Consultation Response from KC, Conservation & Design

2023/91280 Bromley Farm Quarry, Barnsley Road, Upper Cumberworth, Huddersfield, HD8 8PD

Extension to previous Bromley Farm Quarry for extraction of clay, shale and incidental coal

Date Responded: 18.07.2023

ACCESS TRACKING

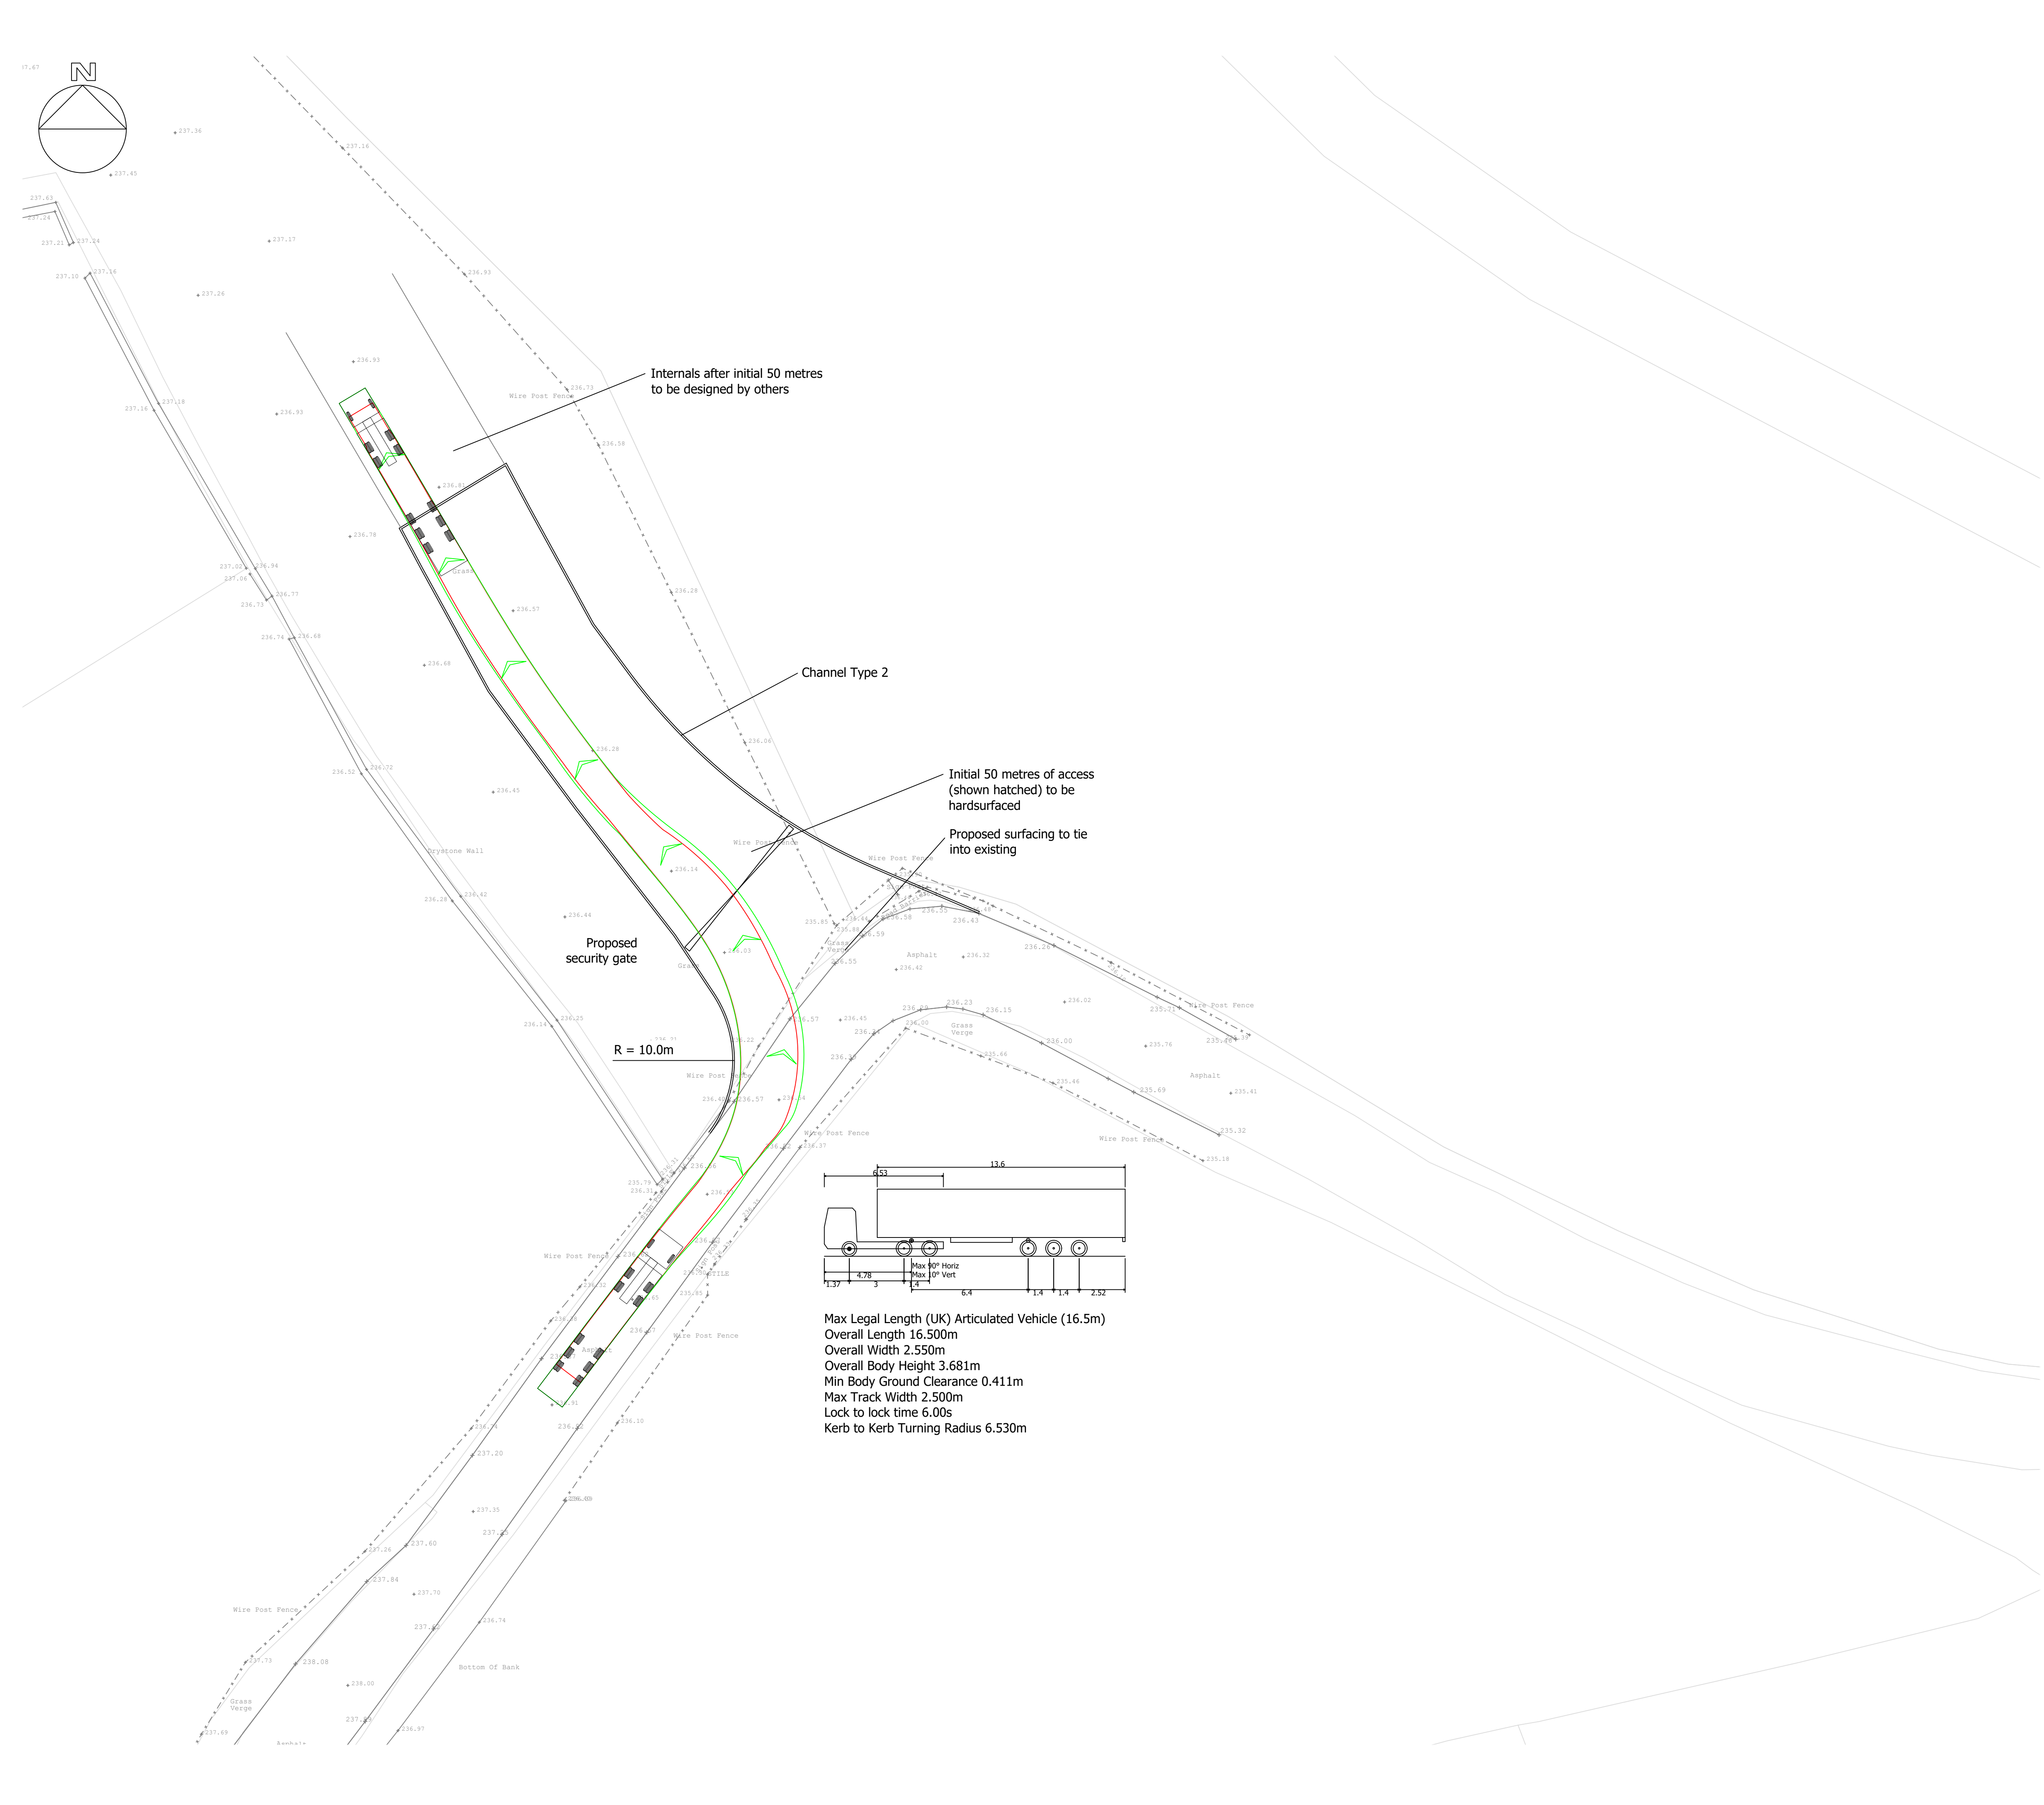
We consider that there is a need to give further consideration to the location and route of the access track. We would query whether the access track would be relocated and positioned further to the south. In addition, we consider that additional planting would be required to the northern boundary. We would also highlight that the new quarrying operation will provide increased noise and visual harm during the time of operation.

As presented, we consider that as set out there are certain elements which require further consideration. Including the route of the access track and the addition of further planting to the northern boundary. Consideration also needs to be given to the length of the quarrying operation and the treatment of the site post-use.
